PLAN REVIEW SHEET

Petition #: RZP 2021-176

Address: 4435 Randolph Rd.

Request: B-2 (CD)

CONCEPTUAL REZONING PLAN SCALE: 1" = 20'

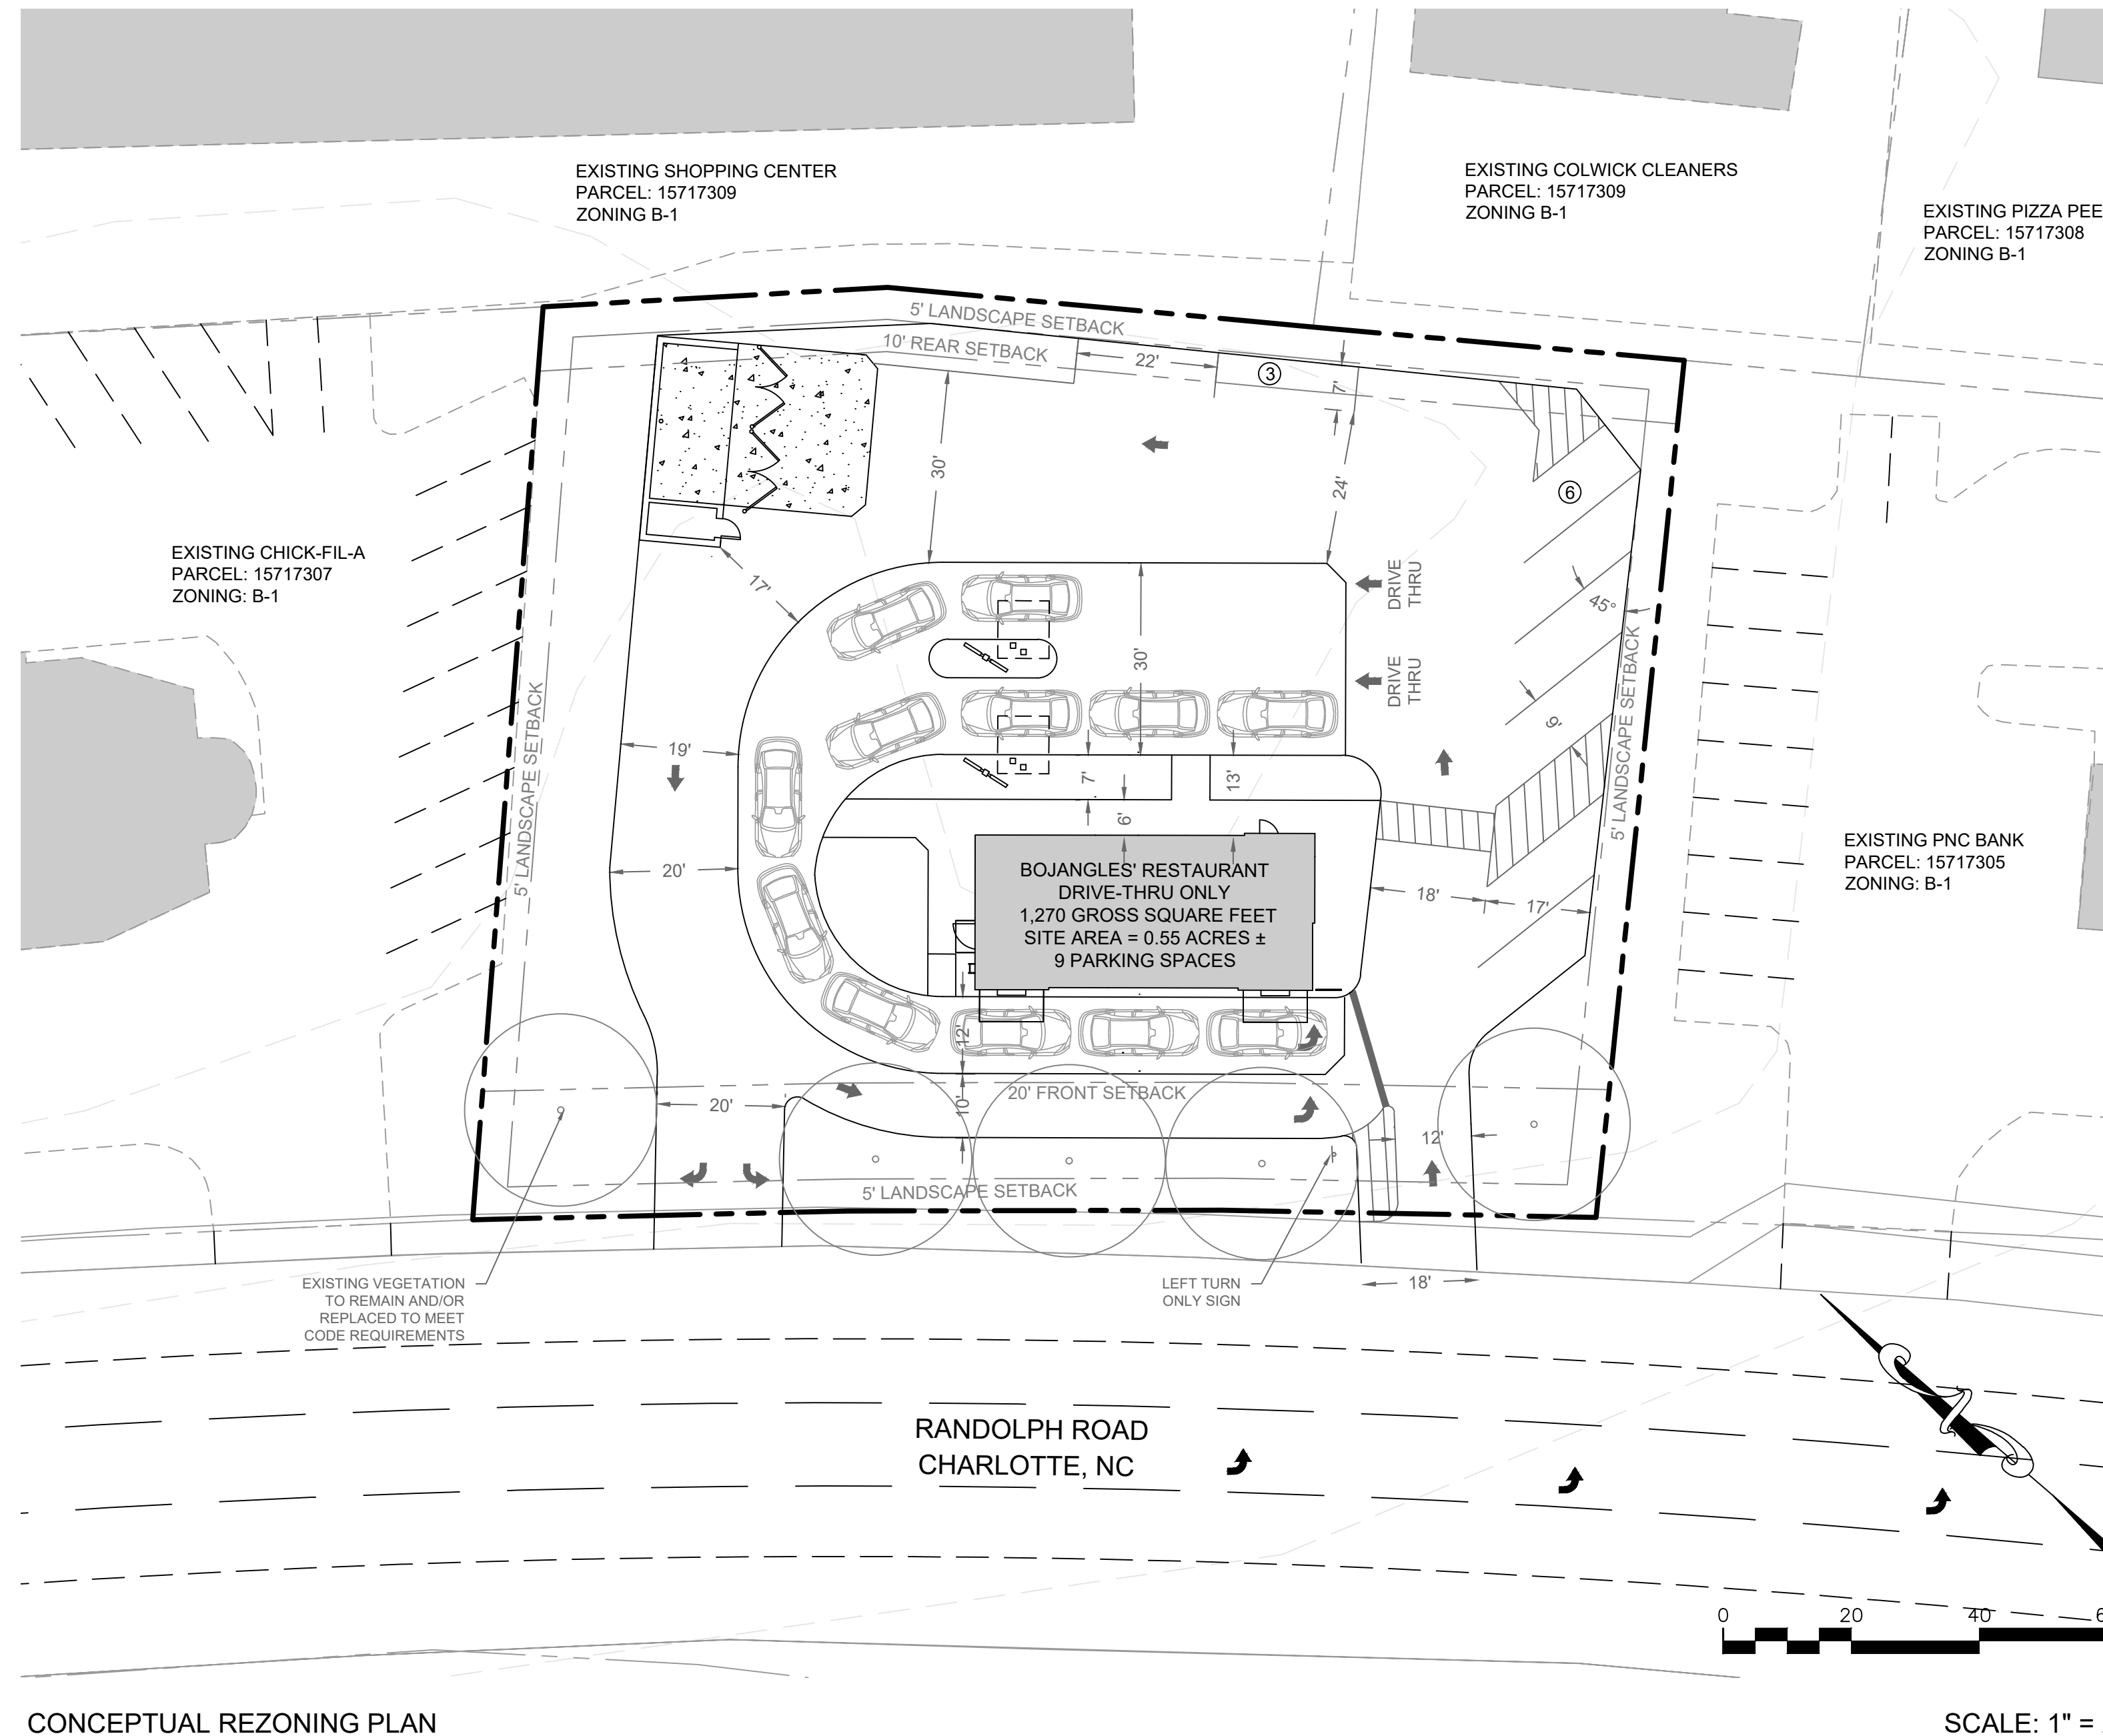
The site is located along CATS local bus routes #15 and #62x on Randolph Rd. The site plan does not show a 6' sidewalk and 8' planting strip. However, if a new sidewalk and planting strip are required CATS requests the construction of a shelter pad and ADA compliant waiting pad per Land Development Standard 60.03A on Randolph Rd. The final location of the pad will be coordinated with the developer through the permitting process.
